From: Planning
Subject: FW: NC2/3/2020/0763 - Brabins Shop and Gallery, 20-22 Talbot Street, Chipping, Preston, Lancashire, PR3 2QE - SPAB Response

Application ref: NC2/3/2020/0763

Address: Brabins Shop and Gallery, 20-22 Talbot Street, Chipping, Preston, Lancashire, PR3 2QE

Proposal: Application for listed building consent to undertake works to the building, insertion of replacement windows (like for like), replacement of roof coverings and the erection of new rainwater goods.

Title: **FLOOR PLANS AND SECTIONS PROPOSED LAYOUT**

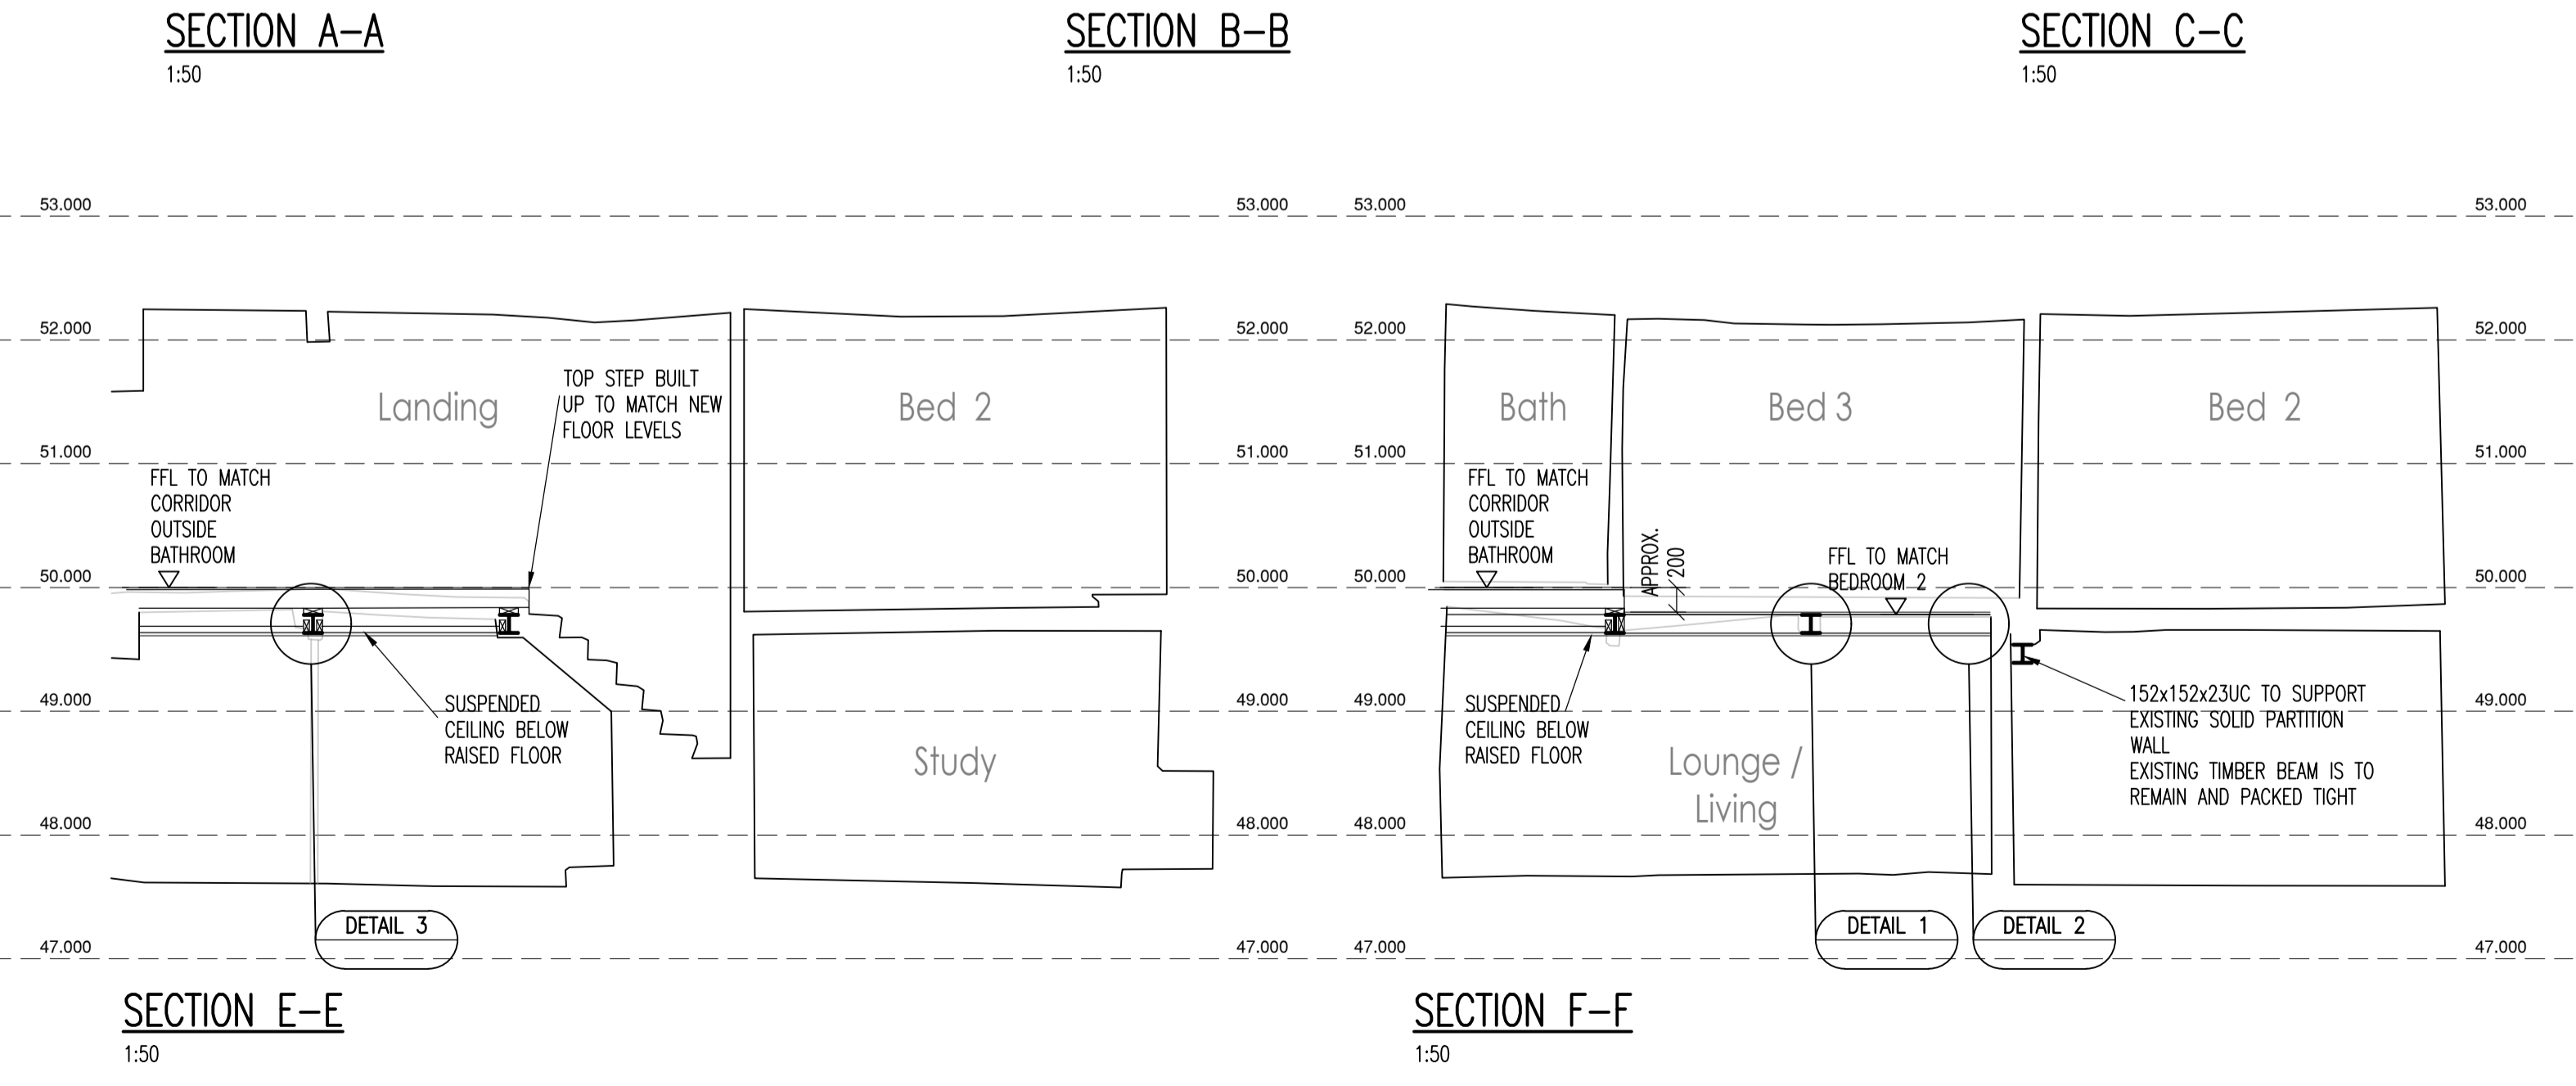
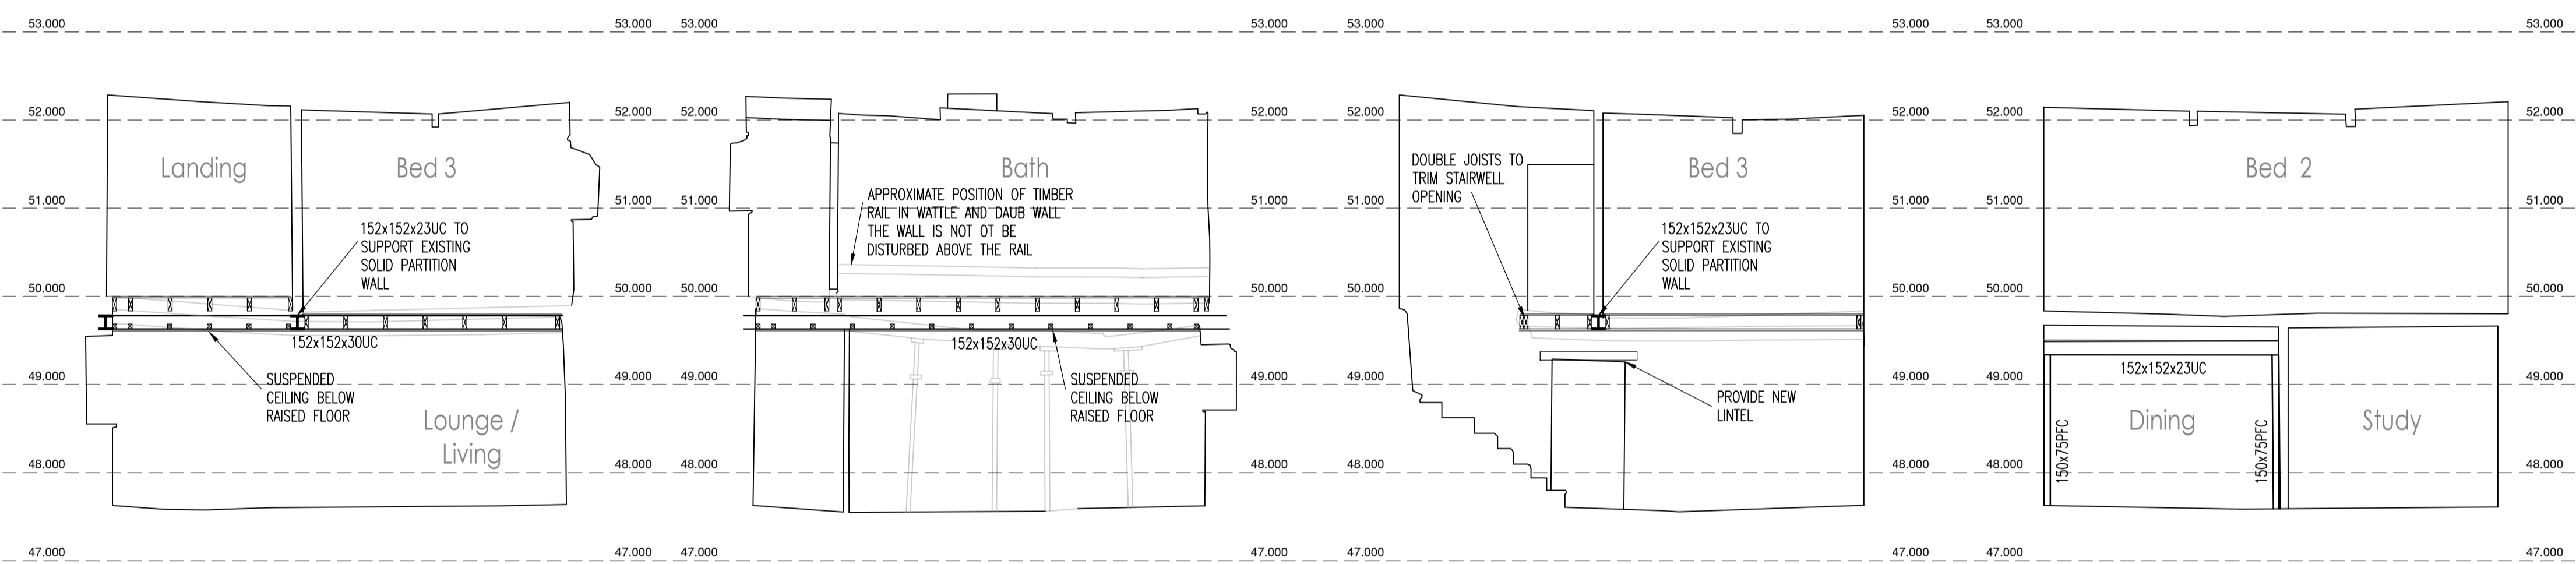
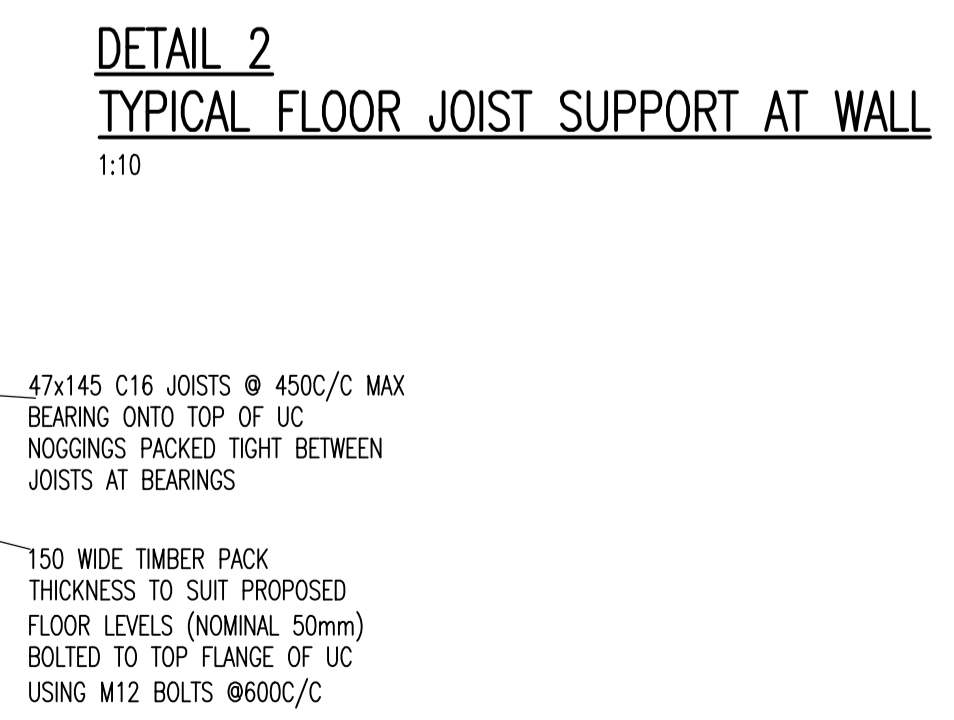
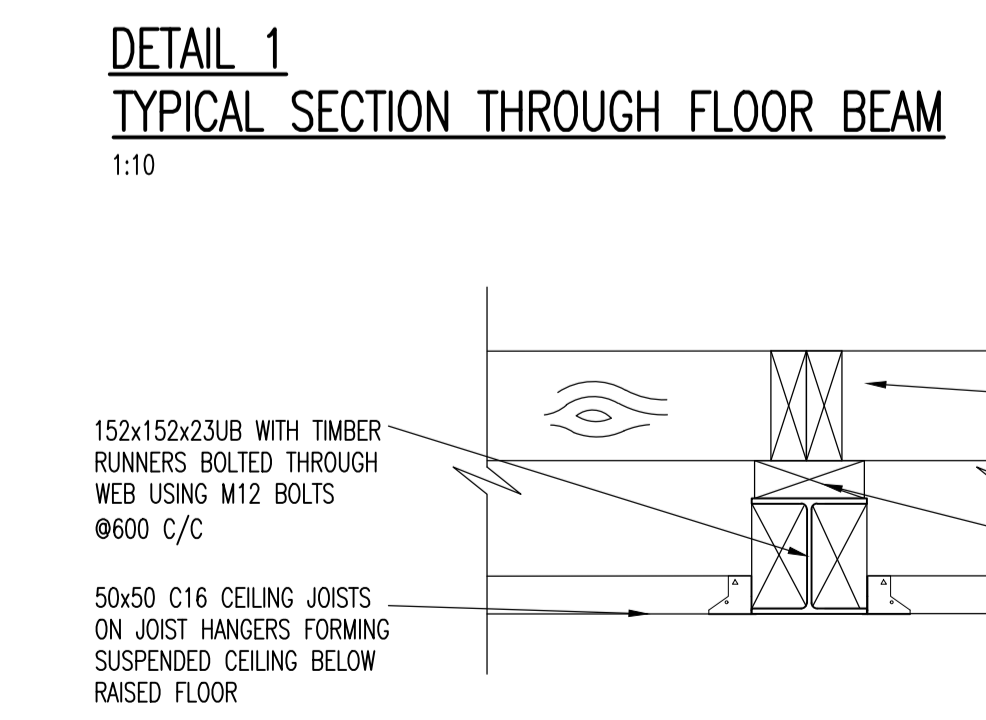
Unfortunately, the Society remains concerned by the proposed structural works and believes that a less invasive and destructive solution may still be possible. In their response, the agent advises that they "have thoroughly explored the possibility of retaining the existing fabric to the first floor. Various means have been considered but the constraints within the building preclude most of these options if the building is to be inhabited and practical as a living space." However, the options reported to have been explored but considered not to be feasible have not been disclosed.

The agent also advises that the distortion and deflection has been ongoing for some time, presumably meaning the problem is not relatively recent, and that main load comes from the wattle and daub partition. However, this does not tie with the conclusions of the structural report. In respect of the first point, that is the history of the problem, the structural report (paragraph 3, section 4.0 Conclusions) advises that it is considered to be relatively recent. On the matter of loadings, the report concludes that it is a combination of the load from the original partition and additional loads which have been subsequently added (paragraph 2, section 4.0 Conclusions), and that the beam is undersized for the loadings applied to.

It appears that the option of repair was also not fully explored because of the perceived disruption to the first-floor arrangement. However, the solution detailed in the application is immensely disruptive and destructive, and it is difficult to envisage that alternative repair options would be greater in this respect than that which is proposed.

The proposed works would be a significant intervention that would, unintentionally, result in considerable harm and loss. The structural failure is clear, and we do not question the need for intervention, we wonder however if a less harmful solution is possible.

From the information provided, we believe that the option of a bespoke vertical steel splice (installed from the underside) to strengthen and repair the existing beam (and gently raising the beam to straighten it out slightly) may be possible (and may be possible with minimal disruption). A similar repair might also be possible to the dining room beam. We strongly encourage that these options be fully explored.

We also strongly encourage significantly reducing the loadings on the first floor (including the removal of the very heavy water tank). These additional/increased loads appear to have been a factor in the failure of the floor which has survived some considerable time.

Notwithstanding the above, it is perhaps also worth noting that we also do not support the approach to clad and decorate modern interventions (in this case - the steel beams) to mimic the historic beams.
